From: Simon Davis
Sent: 11 March 2019 11:48
To: [REDACTED]
Subject: RE: BR/326/18/PL - The Royal Hotel, The Esplanade, Bognor Regis

From: [REDACTED]
Sent: 25 January 2019 16:52
To: Simon Davis <Simon.Davis@arun.gov.uk>
Subject: BR/326/18/PL - The Royal Hotel, The Esplanade, Bognor Regis

CLIENT	Metamorph Management LLP
PROJECT	The Royal Hotel Apartments
DATE	December 2018
DRAWING TITLE	Proposed Roof Plan

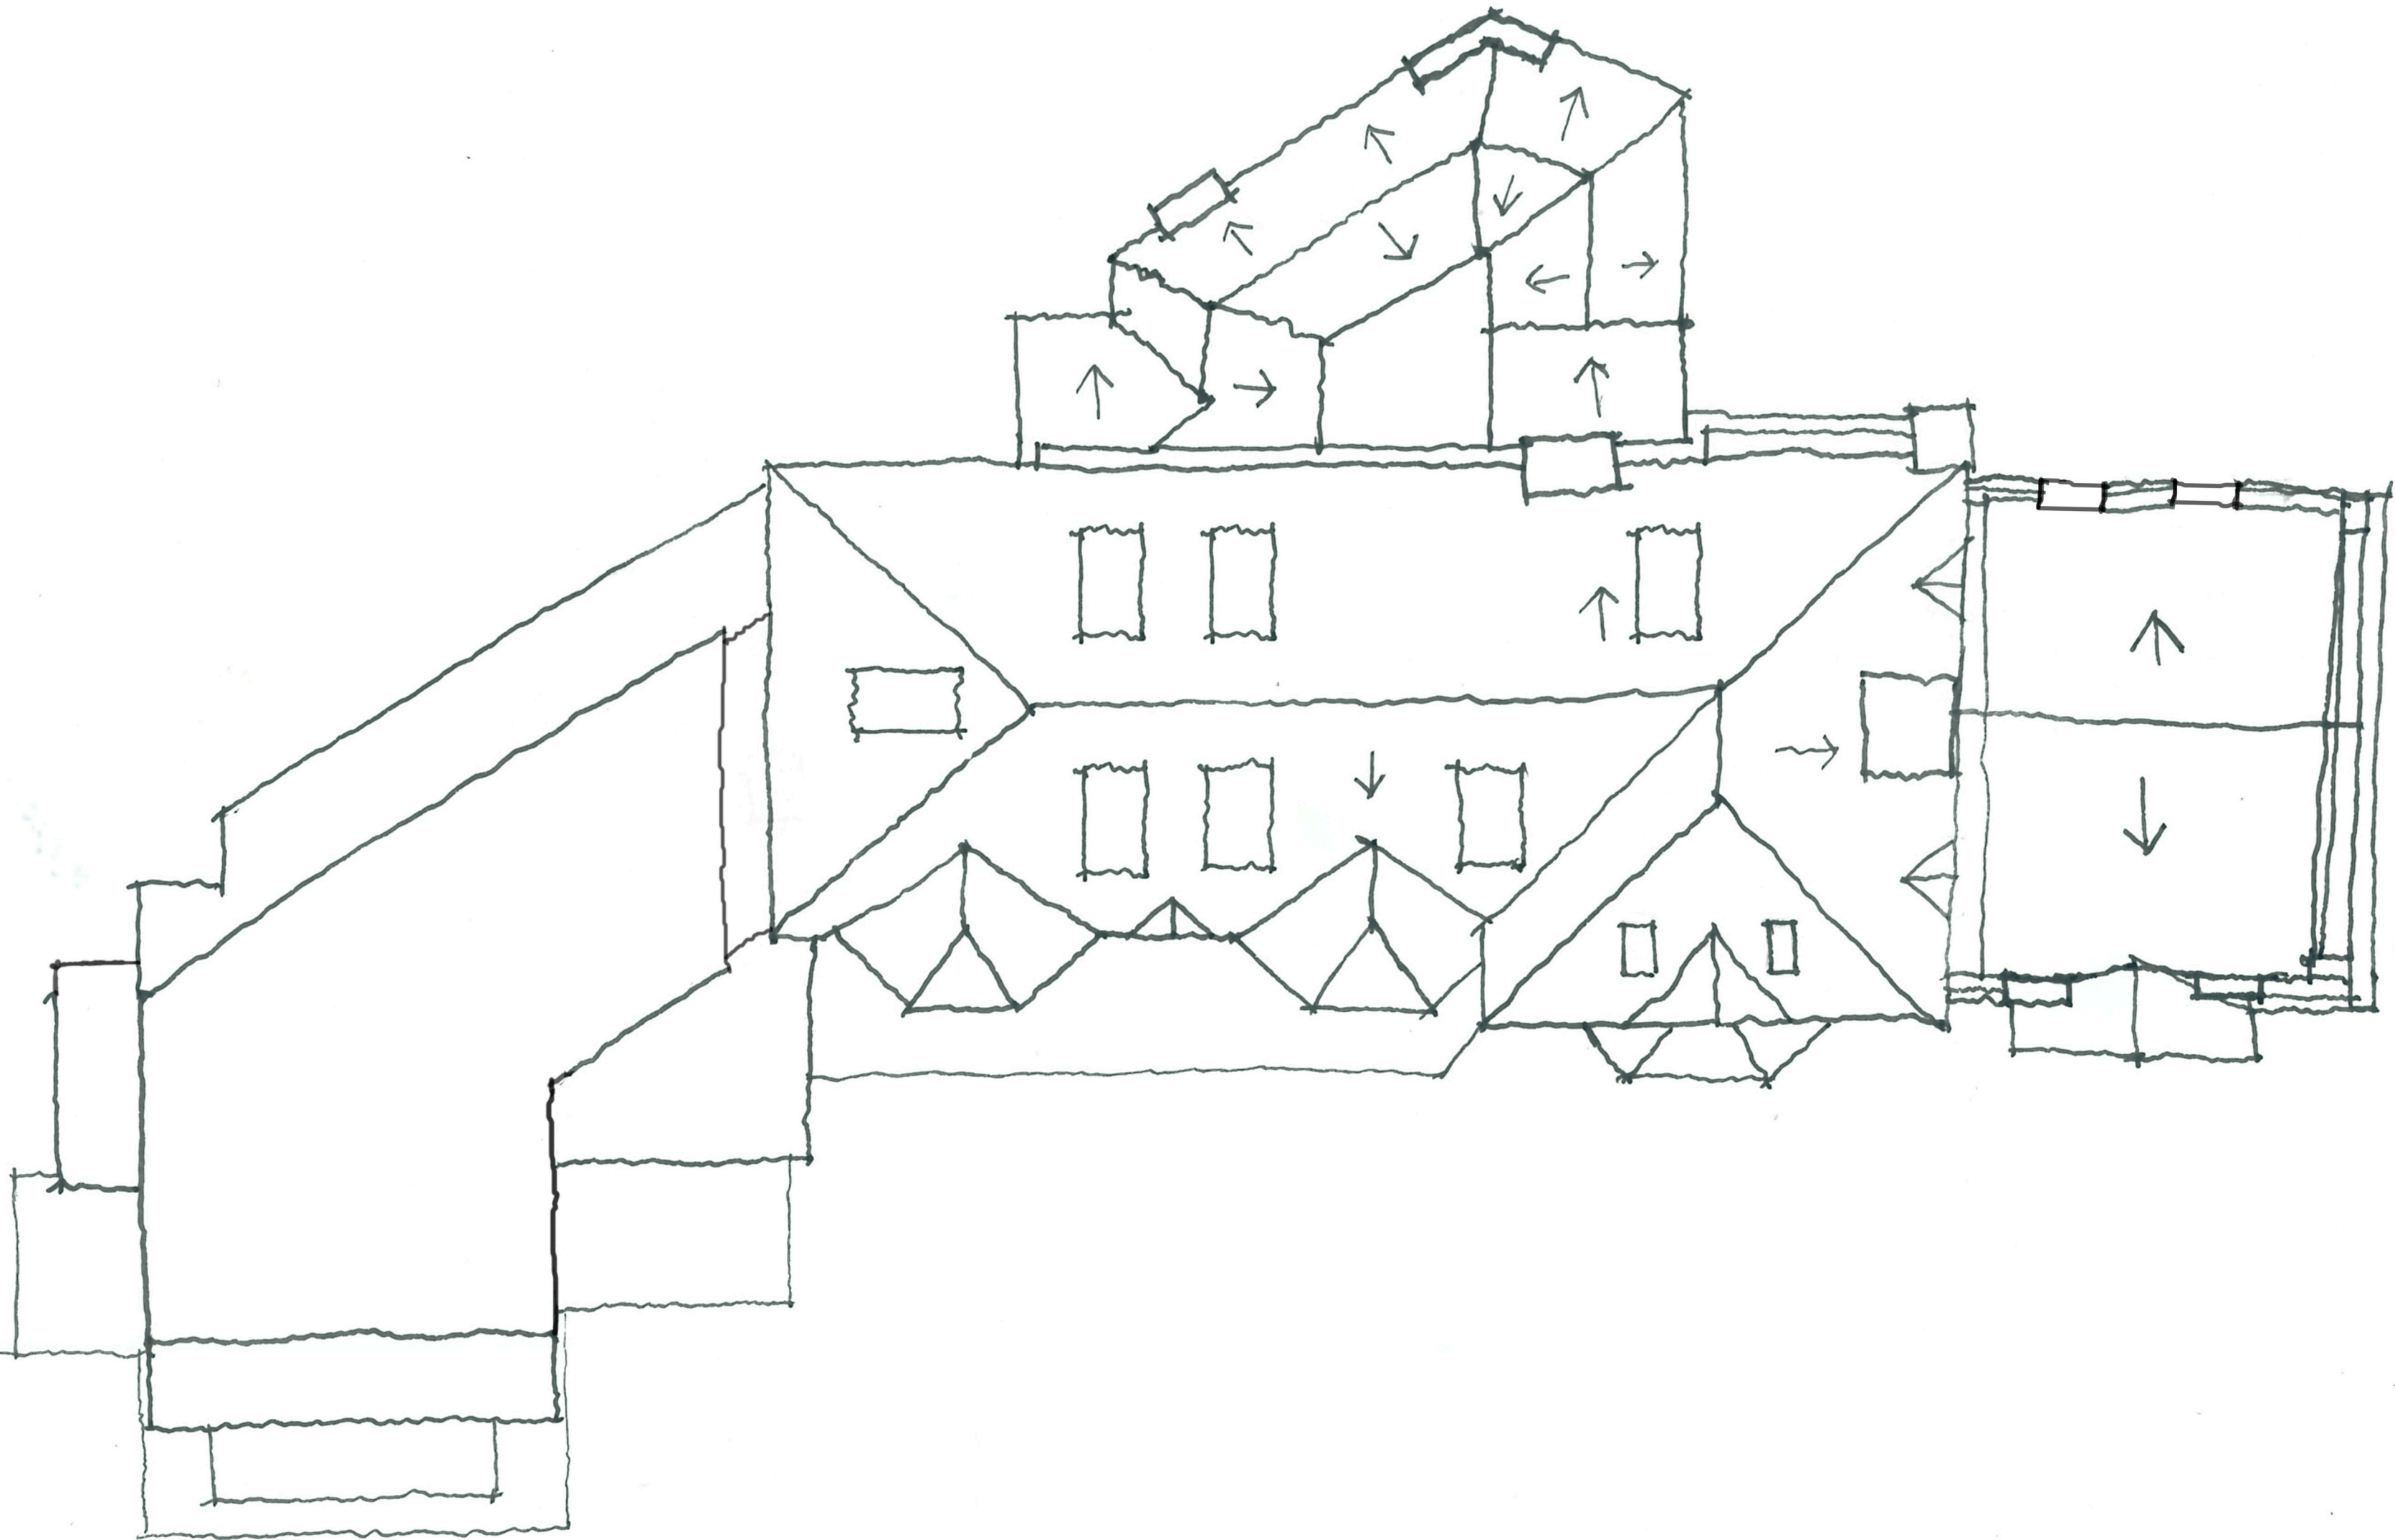
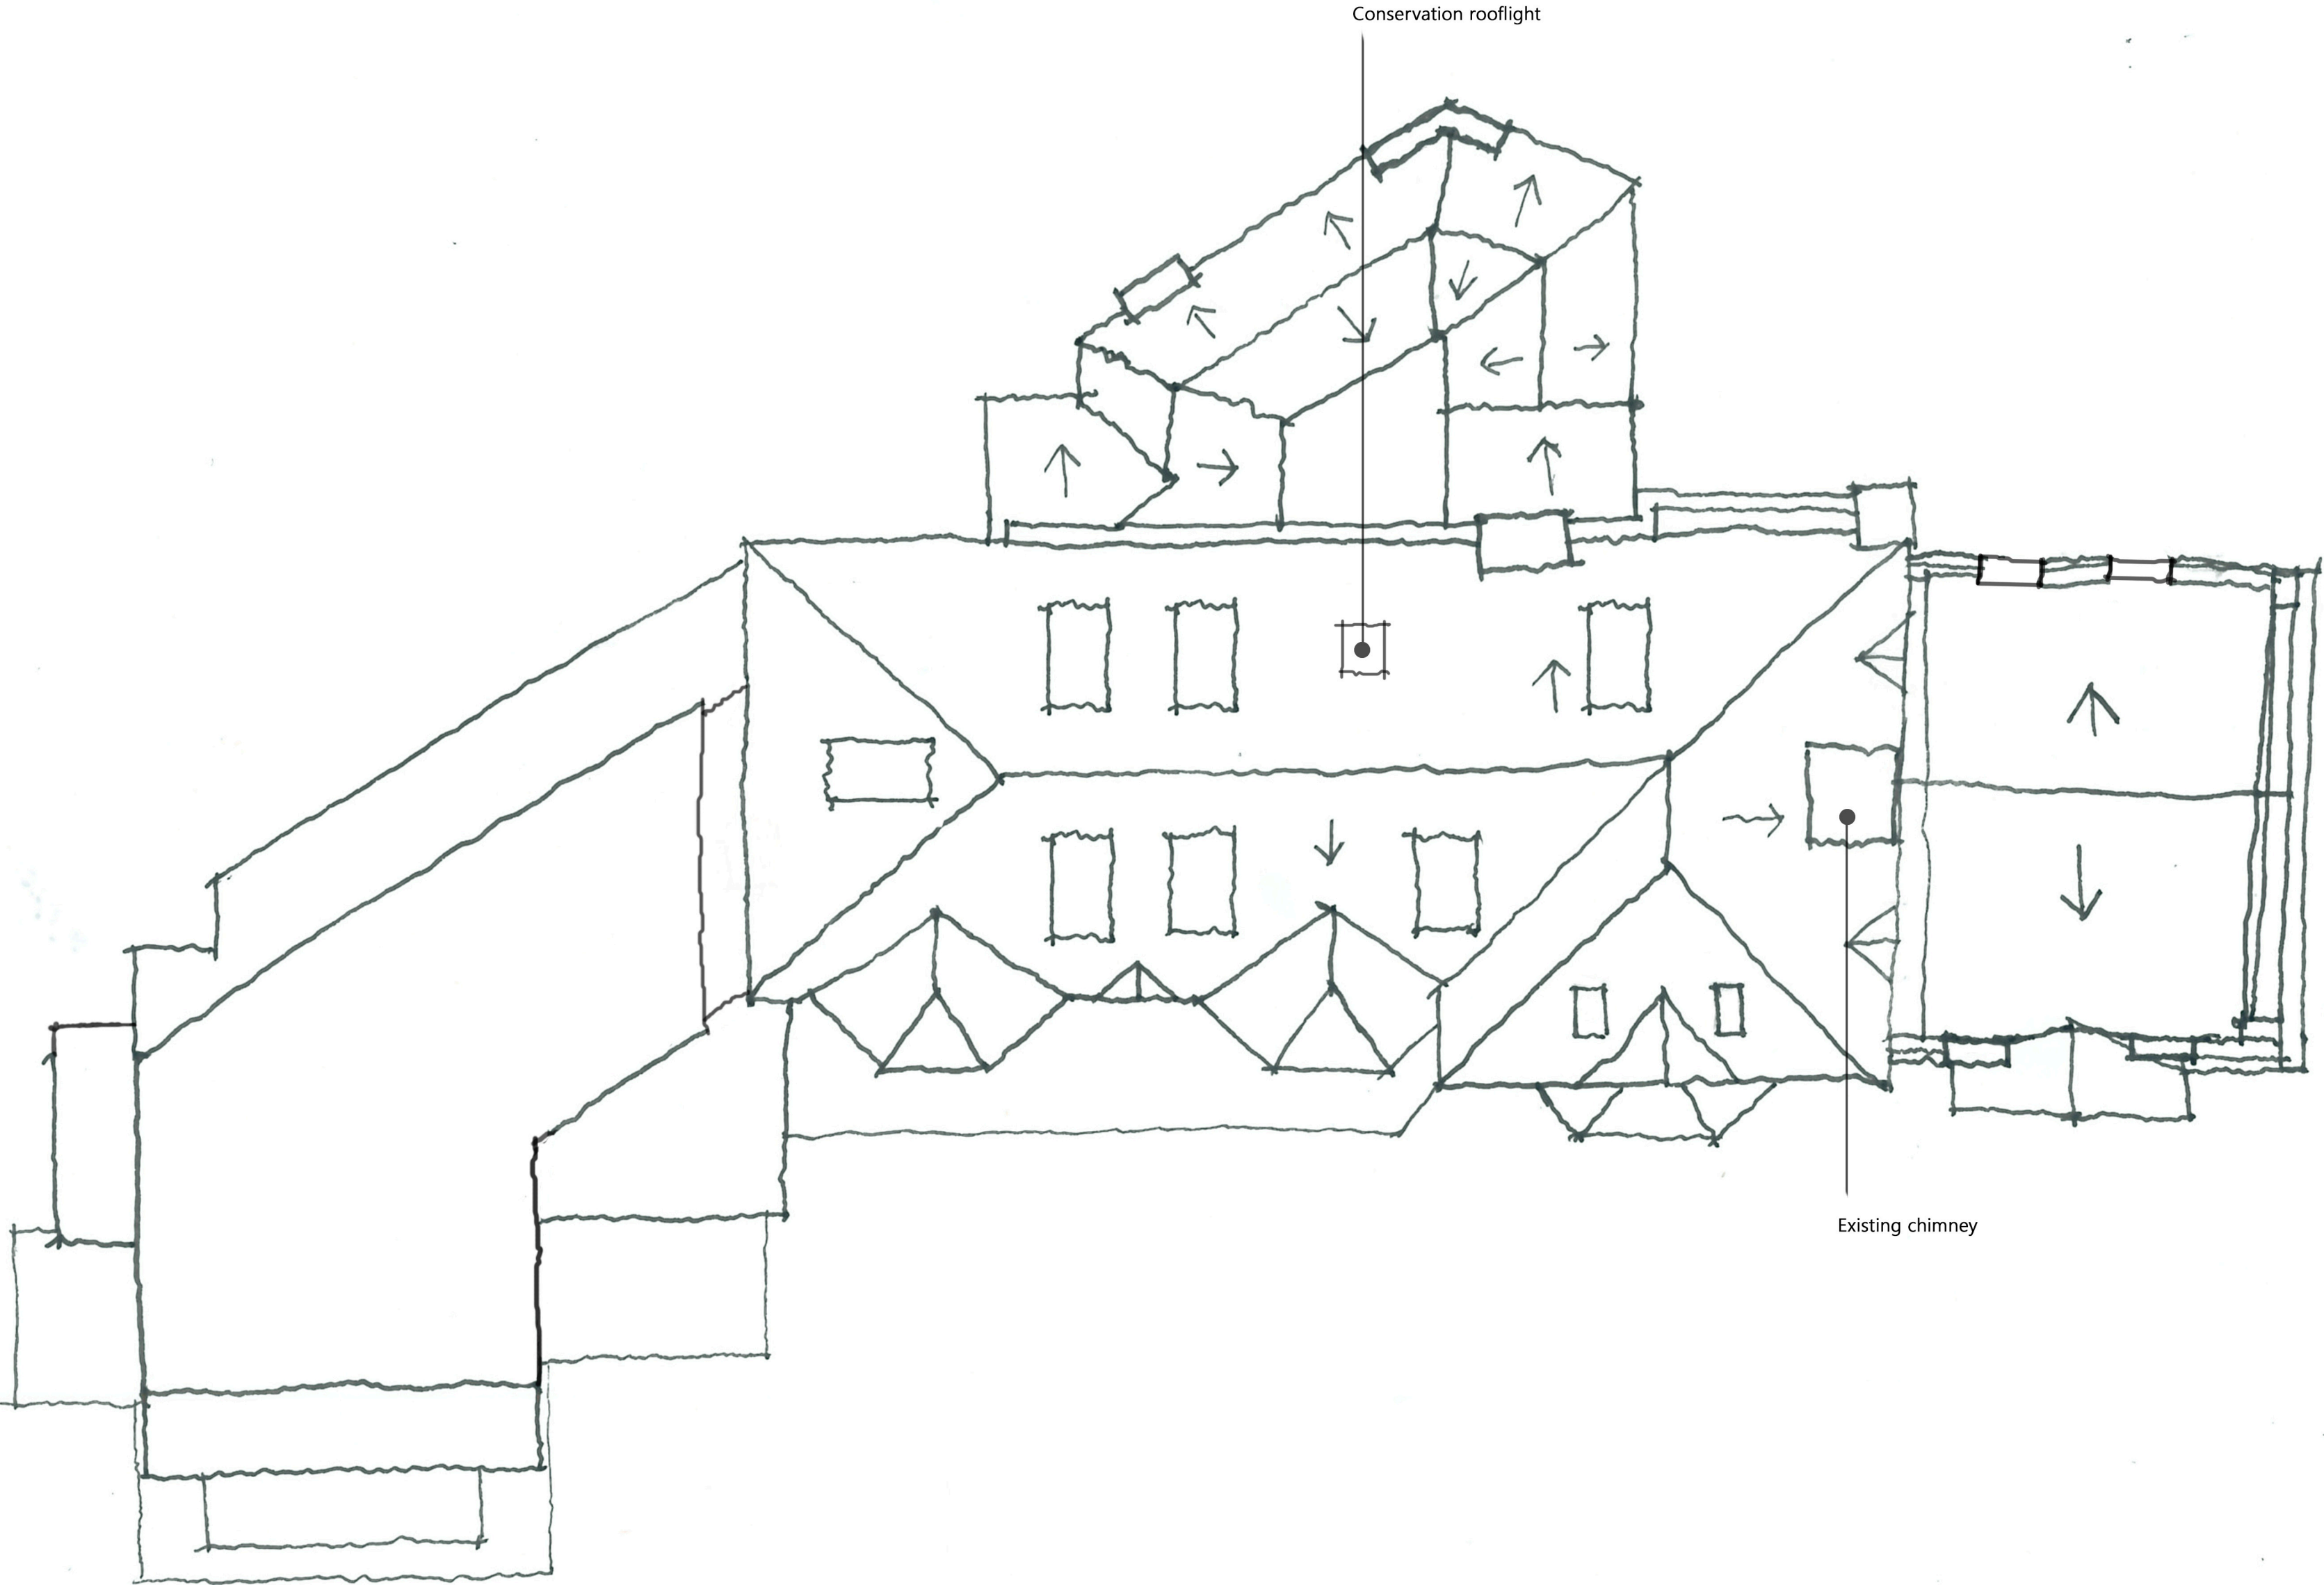
Separately, please see two annotated plans attached. On the roof plan (block plan), it looks like there is a dormer on the eastern flank of the main roof and this is not shown on the N or S elevations. It may be that the missing dormer is actually a velux or the position of the chimney though (as I don't have the fourth floor plan, I haven't been able to check). Also there is a conservation rooflight shown on the N elevation of the main roof but not shown on the roof plan.

One thing he mentioned (and was going to be in his response) was a discrepancy with the plans regarding the dormers on the flank roof planes of the main roof. I think from memory that there are some elevations and possibly the upper floor plan where one or both of these are not shown. I also think he had said that some of the drawings have not made it onto our website. I can't compare to the file at present as Martyn has it but I can't see a third floor plan or an east elevation on the plans we have uploaded. If these are a thing, can you email to me and I'll fix the public viewer. Please also have a look into the dormer issue.

Yes, I think that is a "fair cop", thanks for drawing to my attention, I attach the 4th floor plan but this does not very clearly show the dormer either, so I have requested revised north and south elevations, roof plan and 4th floor plan from the architects. I will forward these ASAP.
